CITY OF ALBUQUERQUE

PLANNING DEPARTMENT – Development Review Services

RE: Sunset Gardens Subdivision (File: K12D003)
Grading and Drainage Plan, Engineer's Stamp Date 1-19-15
Drainage Report, Engineer's Stamp Date 1-16-15

SUNSET VILLA GRADING AND DRAINAGE PLAN	DRAWN BY	WCWJ
		DATE	3-17-16
		21401-LAYOUT-1-06-13	
		SHEET #	6 OF 25
		JOB #	21401

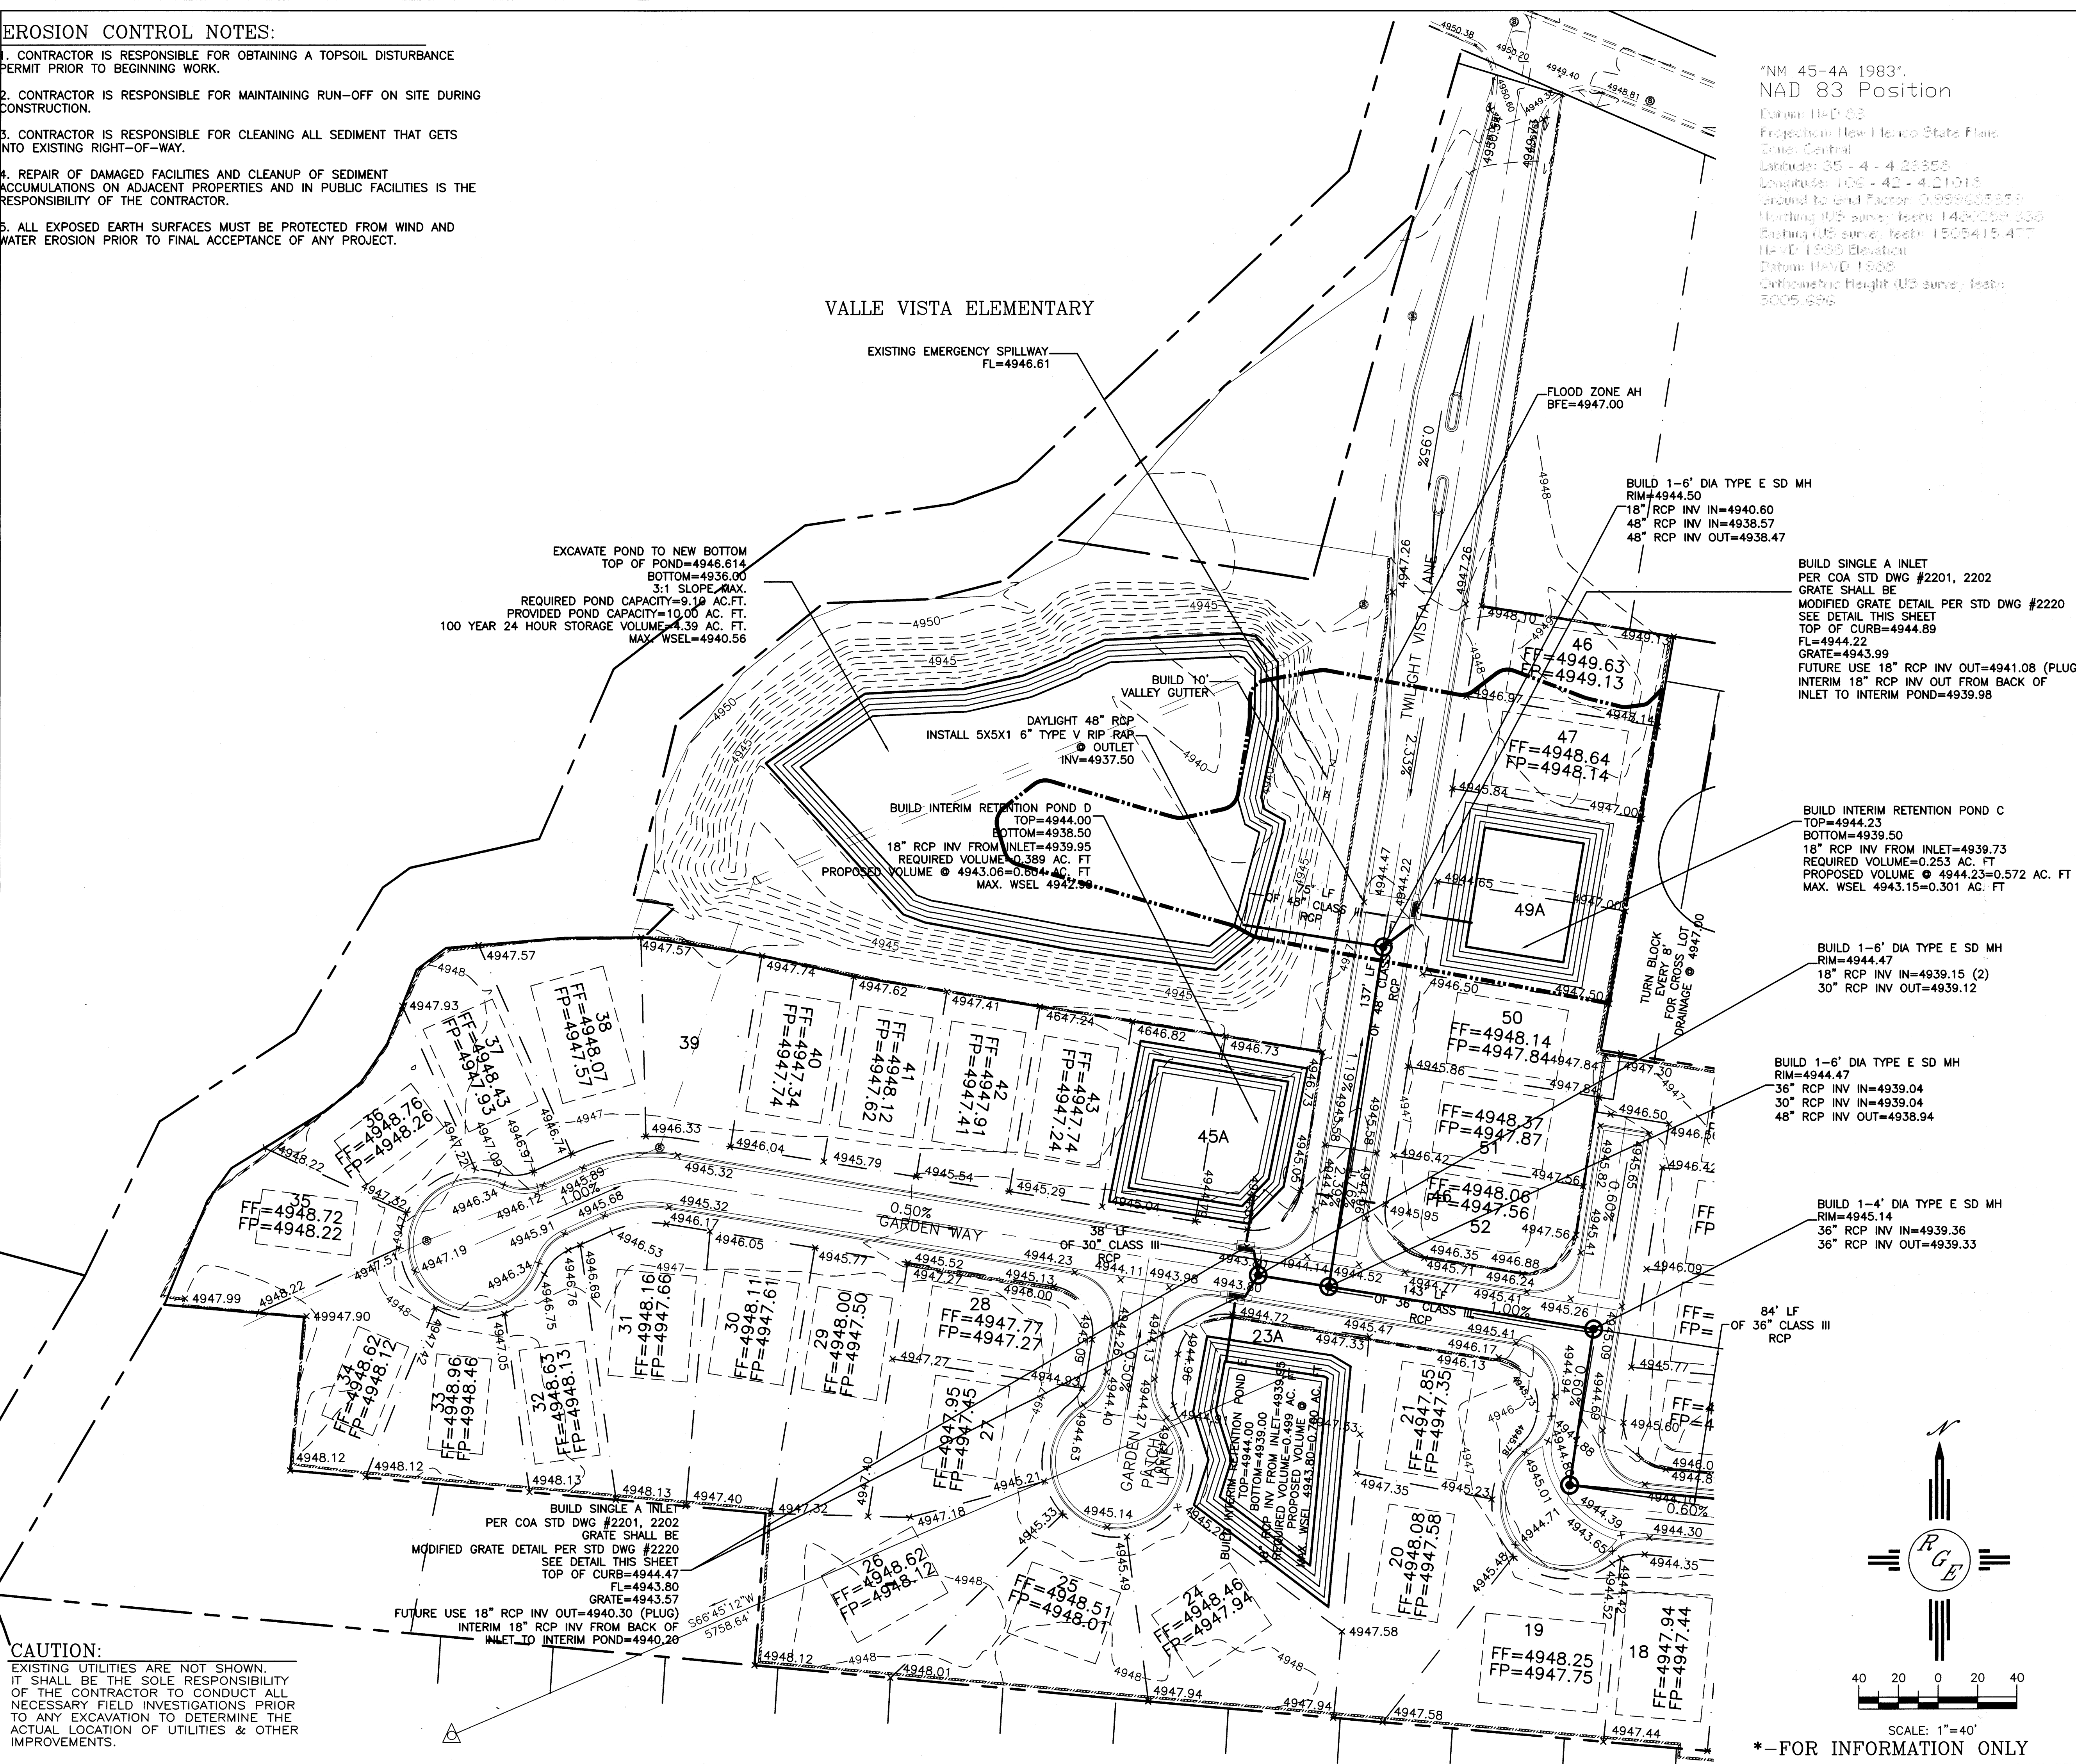
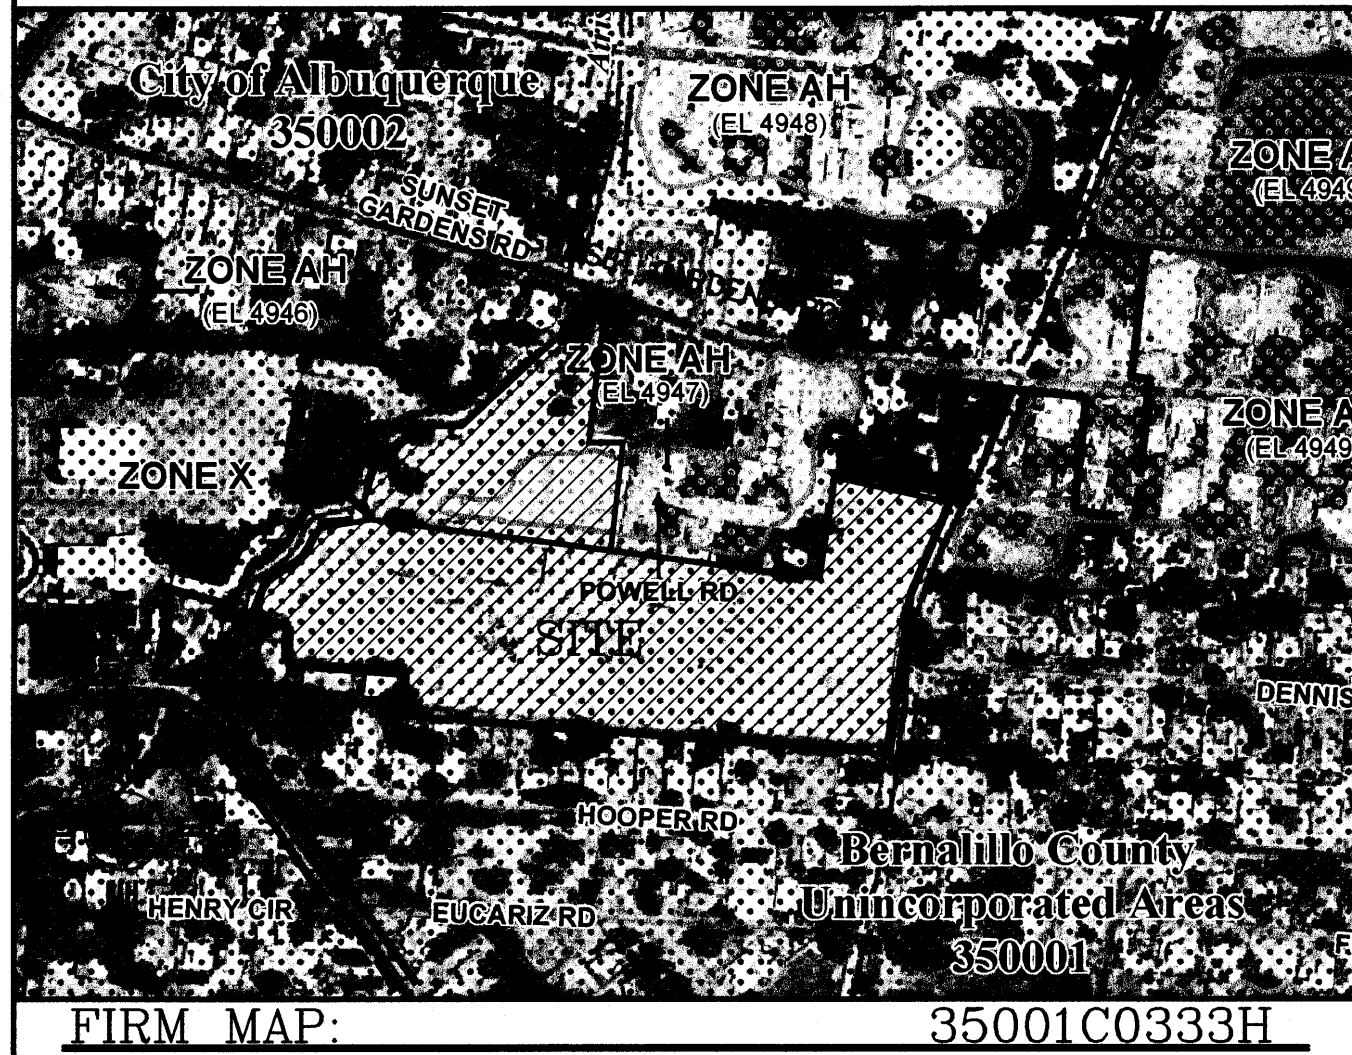
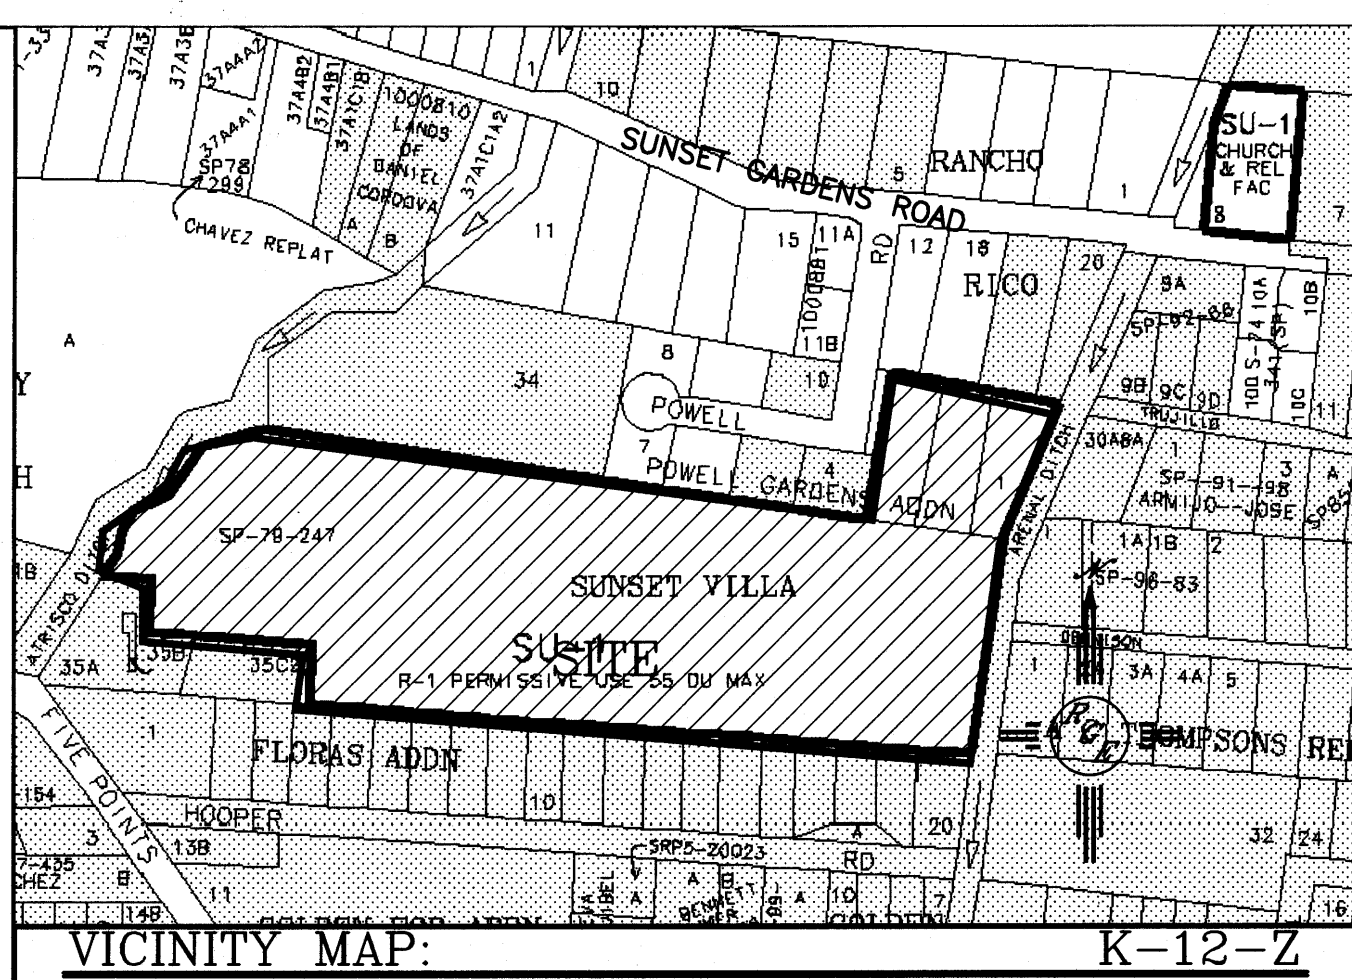
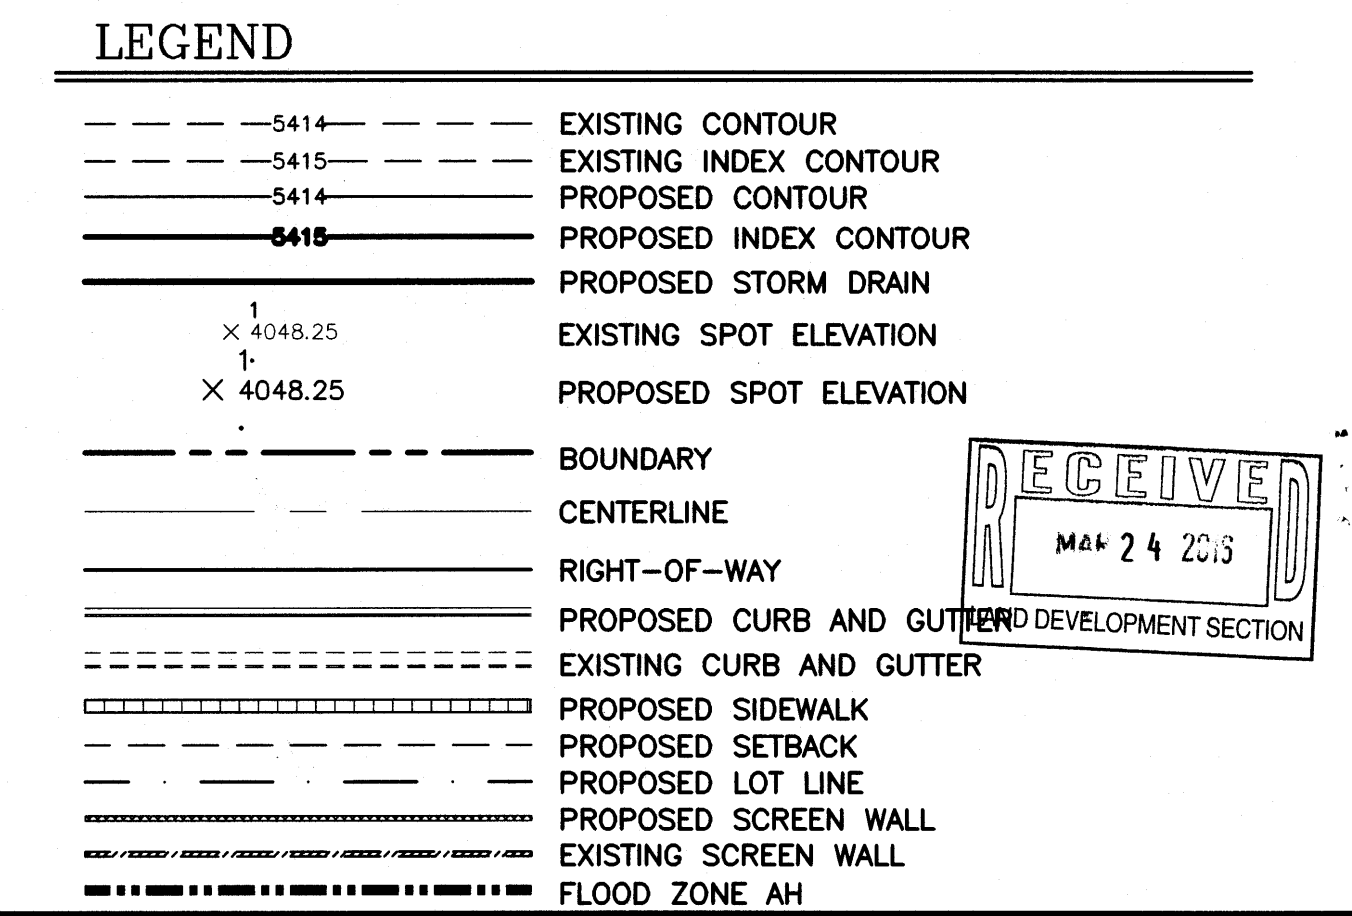
4. Lots 68 and 5 have an irrigation and utility easement thru them which should be shown on the Grading Plan. The pad crosses the easement. All easements should be shown on grading plan, including the utility easement.
